**KIRKLEES METROPOLITAN COUNCIL
INVESTMENT & REGENERATION SERVICE**

**DELEGATED DECISION FOR APPLICATION FOR CERTIFICATE OF
LAWFUL DEVELOPMENT**

Reference no.: 2026/CL/90735/E

Site: 85, Combs Road, Thornhill, Dewsbury, WF12 0LD

Project 85 COMBS ROAD DEWSBURY WF12 0LD	
Drawing PROPOSED BLOCK PLAN	
Dwg No. 106	Date JANUARY 2026
Scale @ A3 1:500

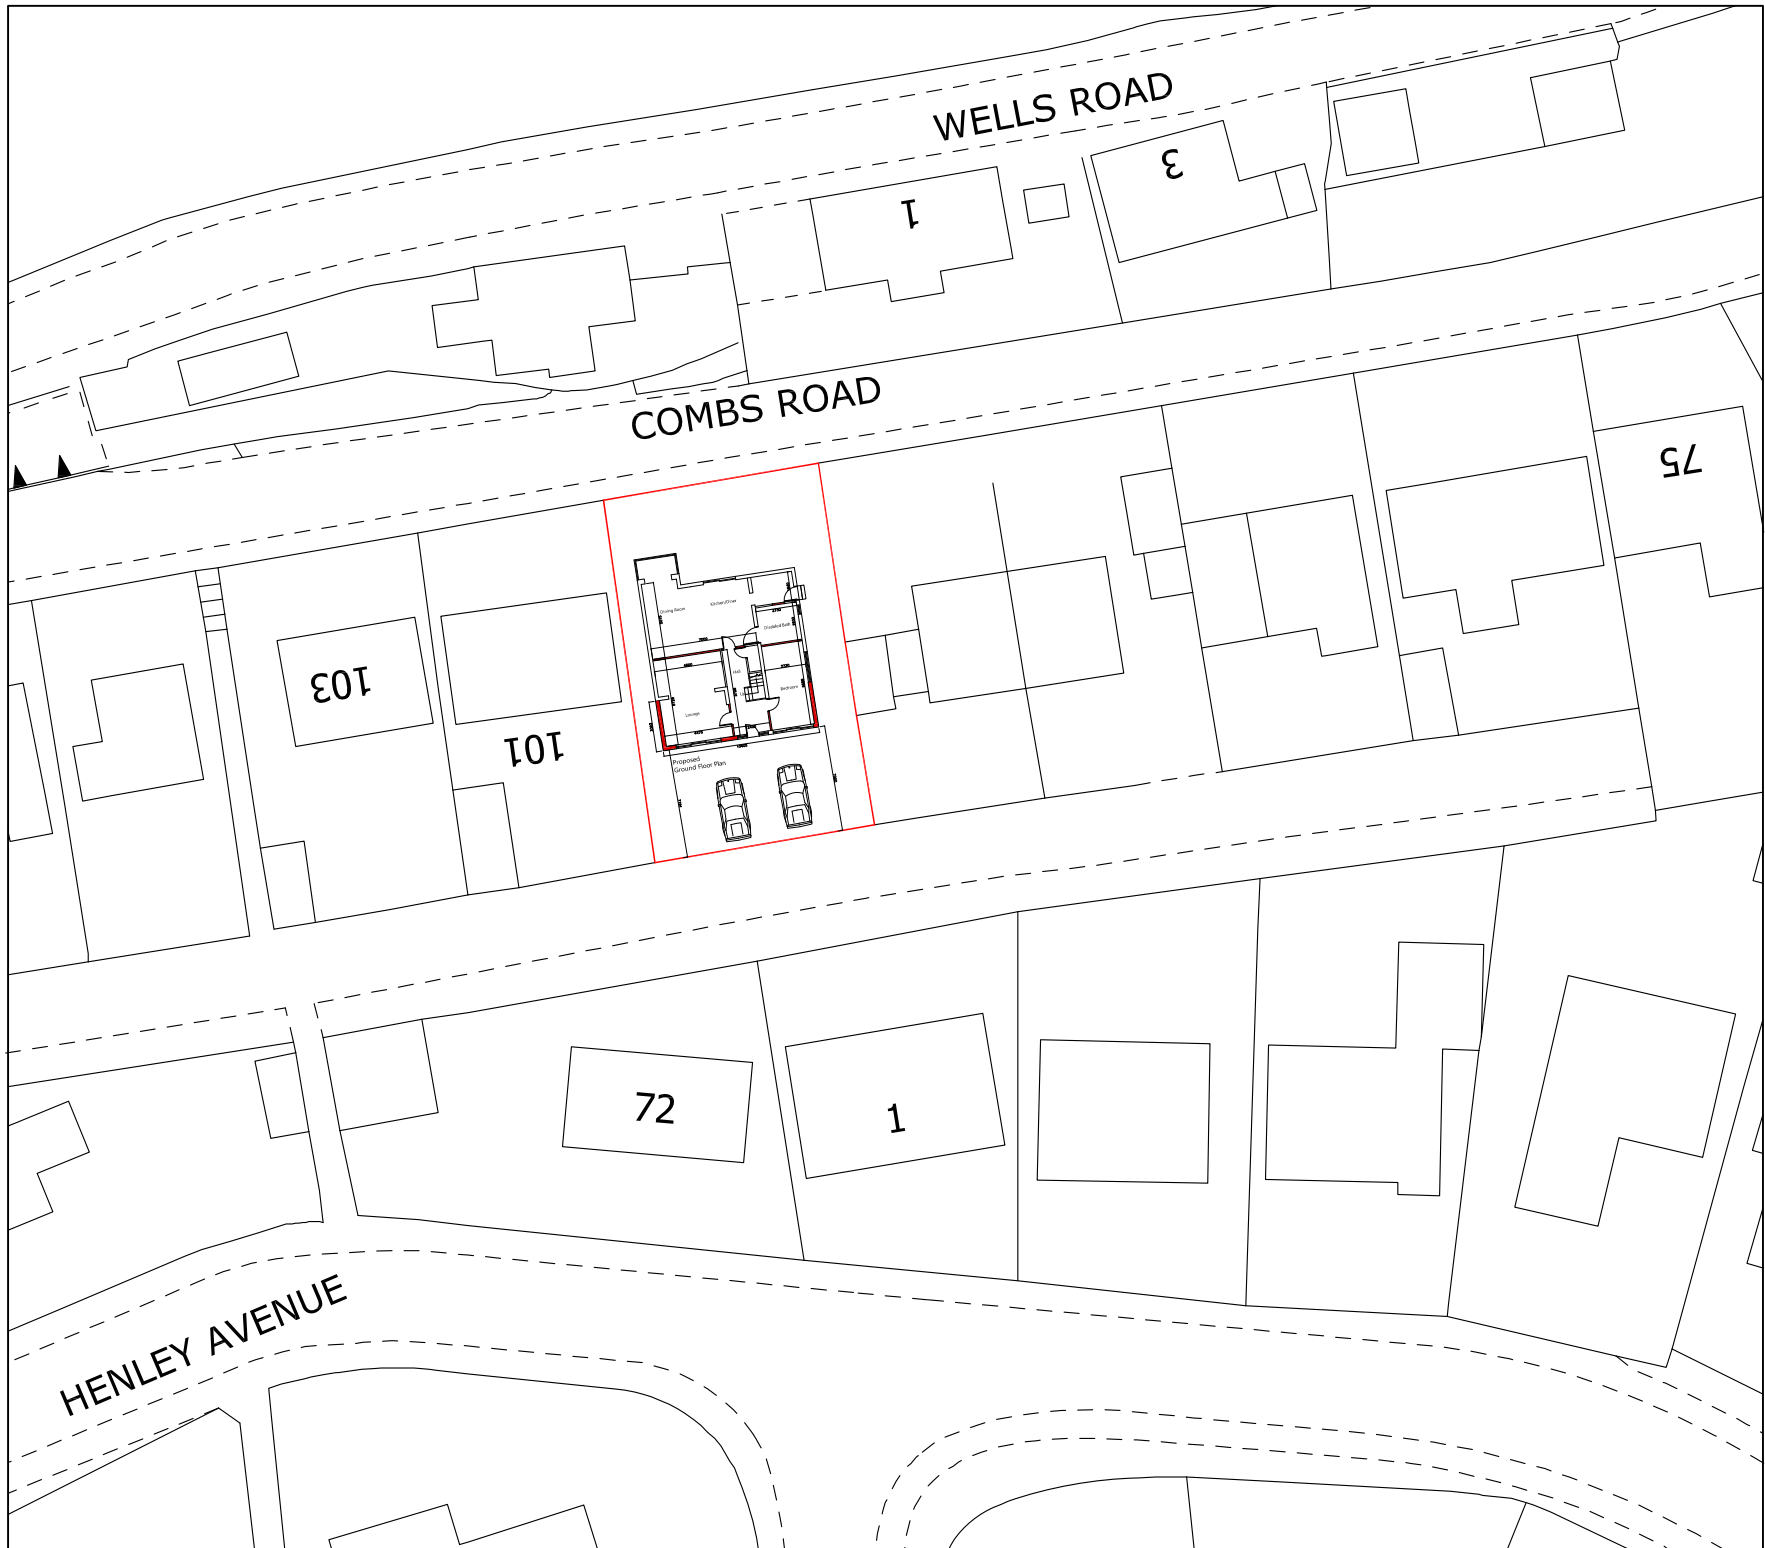
Comment: *The enlarged part of the dwellinghouse would be within 2 metres of the boundary of the curtilage of the dwellinghouse and would have an eaves height which exceeds 3 metres in height.*

Drawing
PROPOSED ELEVATIONS

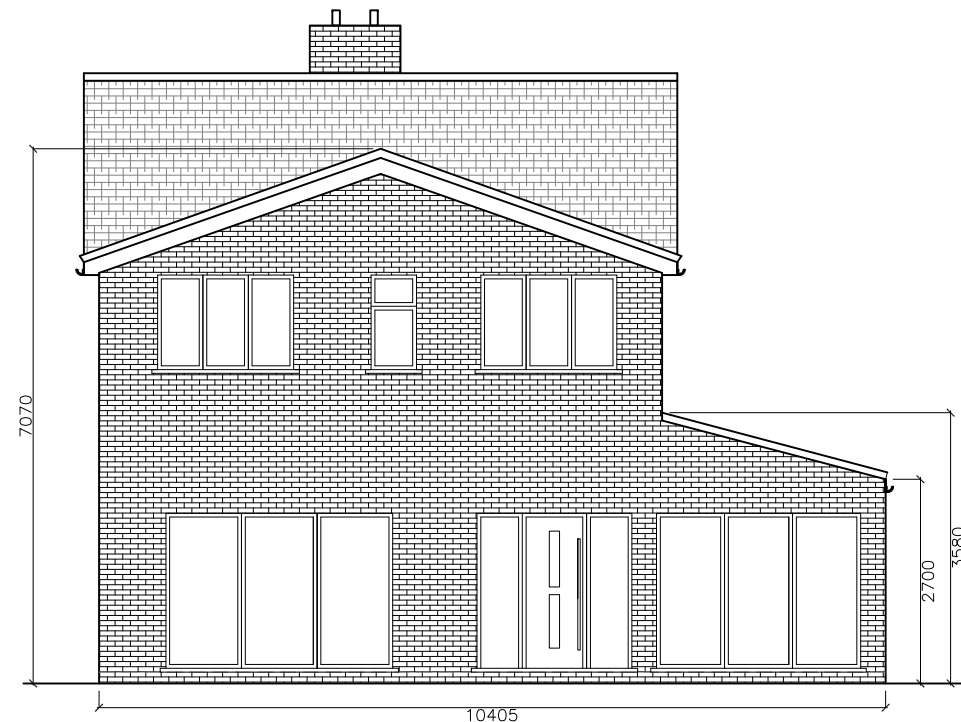
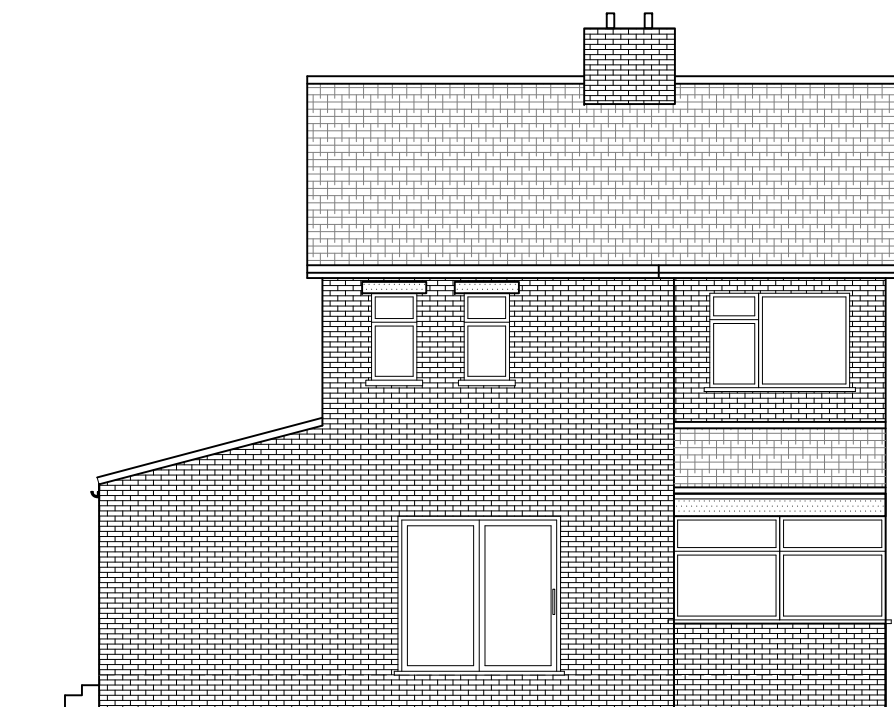
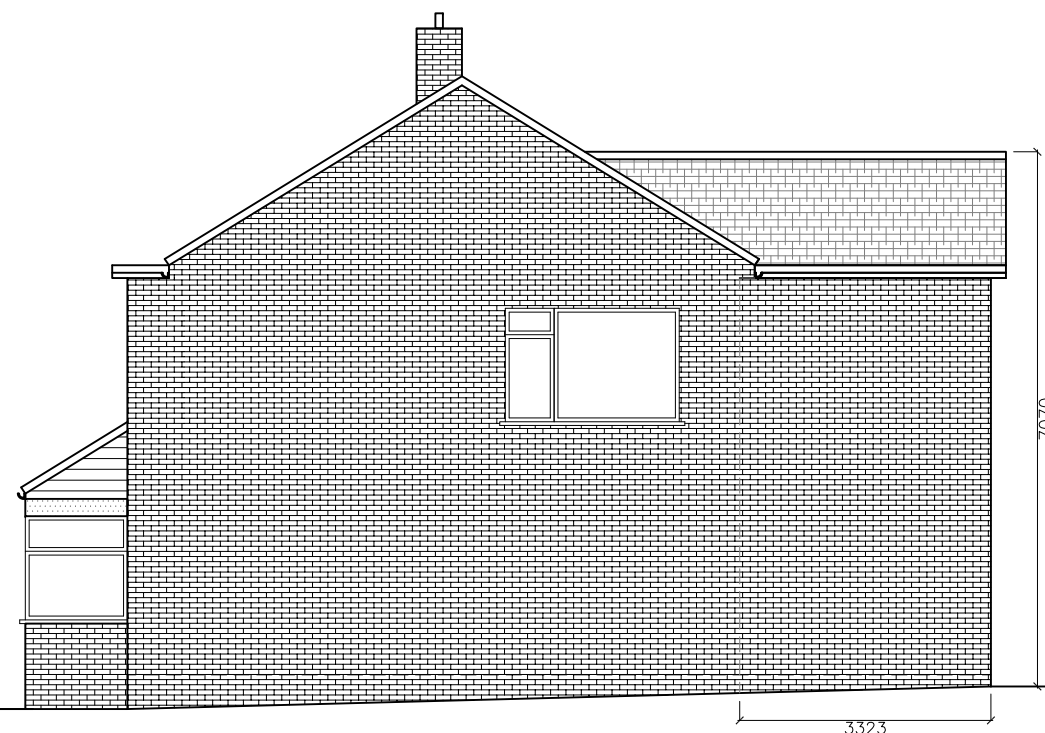
The proposed extension would sit behind the two-storey body of the property. The plans are annotated and state that the extension would project 3,323 metres from the rear elevation of the property with an eaves height of 5.5 metres and overall height of 7.020 metres.

Comment: *The enlarged part of the dwellinghouse would be more than a single storey and it would be more than 7 metres from the boundary opposite the rear wall of the dwellinghouse. However the enlarged part of the dwellinghouse would extend more than 3 metres from the rear elevation of the original dwellinghouse.*

Comment: As demonstrated within the image above, a side elevation of the original building is located to the rear of the property. As such, the enlarged part of the dwellinghouse would extend beyond a side elevation would exceed 4 metres in height, would have more than a single storey and would have a width greater than half the width of the original dwellinghouse by virtue of spanning the full width of the rear elevation. In terms of the garage extension as this would attach to the rear of the garage and alters the roof form of the original feature, by virtue of its attachment to the proposed two storey element of the proposal, this also fails to meet criteria (i), (ii) and (iii) above.

Drawing
PROPOSED PLANS

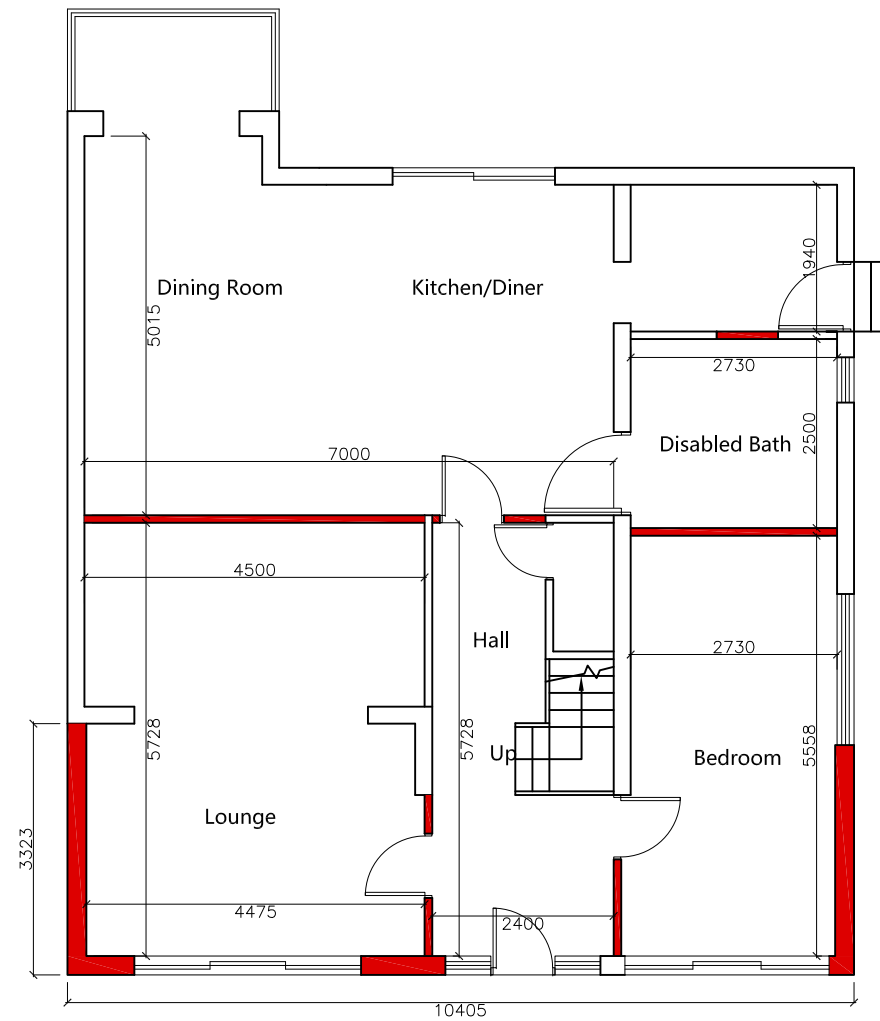
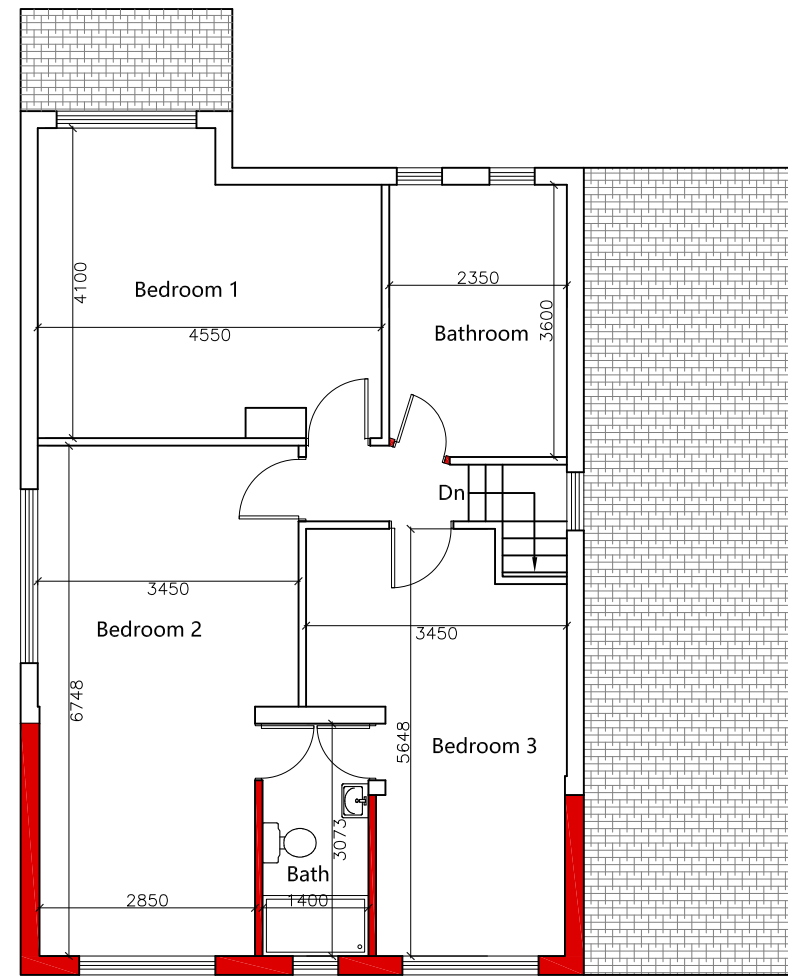
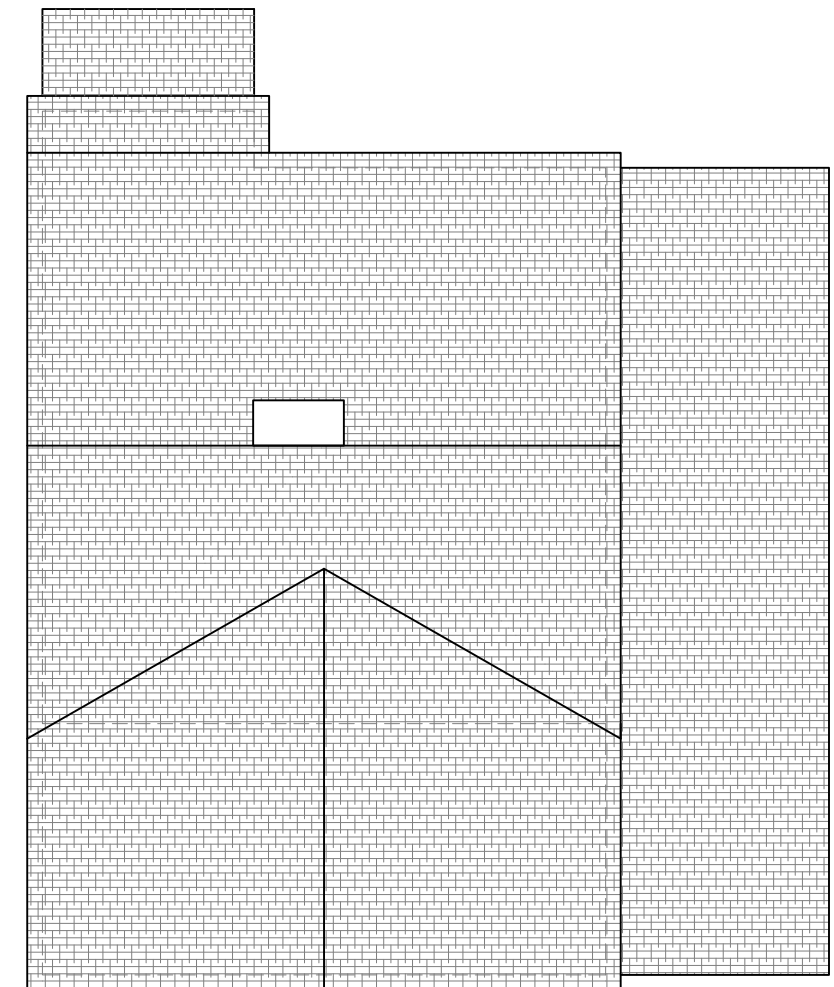
It is proposed that the existing garage would be converted and the internal space at ground floor reconfigured to a bedroom and bathroom. The existing garage door would be walled up and 3 no. elongated windows installed.

It is also proposed that the rear of the garage would be extended and attach to the proposed two storey extension lying flush with the rear elevation of the proposed extension. In addition, the flat roof of the garage would be removed and replaced with a lean-to roof.

It is also noted that is proposed that the existing garage would be extended by way of a lean-to roof to replace the flat roof and that the rear elevation of the

garage extension would attach to and be incorporated into the proposed two storey extension.

Comment: Page 28 of the Permitted development rights for householders – Technical Guidance states that ‘Where the proposed extension is to be joined to an existing extension to the original house, whether that was built following a planning application or under permitted development rights, the total enlargement (being the proposed extension together with the previous extension) must meet the limits set out in (e) to (j) above’. As the garage is to be extended and attached to the proposed two storey section as would the side extension to the side facing 101 Combs Road, the proposal would be deemed one structure and would fail to comply with the requirements of sub—paragraphs A.1(h), A.1(i) and A.1(j) (i) (ii) and (iii).
